Our Ref: EN010125

6 November 2025

Application by RWE Renewables UK Dogger Bank South (West) Ltd and RWE Renewables UK Dogger Bank South (East) Ltd (“the Applicants”) for an Order granting Development Consent for the proposed Dogger Bank South Offshore Wind Farms (“the Proposed Development”)

REQUEST FOR INFORMATION

Figure 4-1 Indicative timeline for delivery of the predator eradication measure

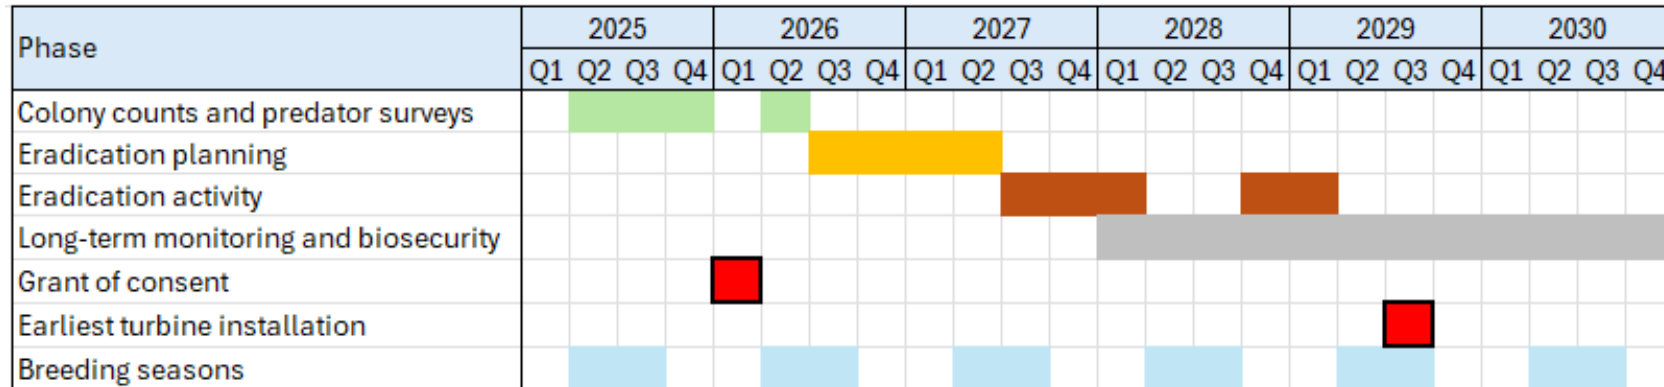
10. The **Applicants** are requested to outline a detailed timetable for when their pre-eradication studies for the selected location(s) will be completed. The Applicants are requested to update Figure 4-1 of the Outline Guillemot [and Razorbill] Compensation Implementation and Monitoring Plan and Plate 6-1 of the Guillemot [and Razorbill] Compensation Plan (Revision 7) accordingly.
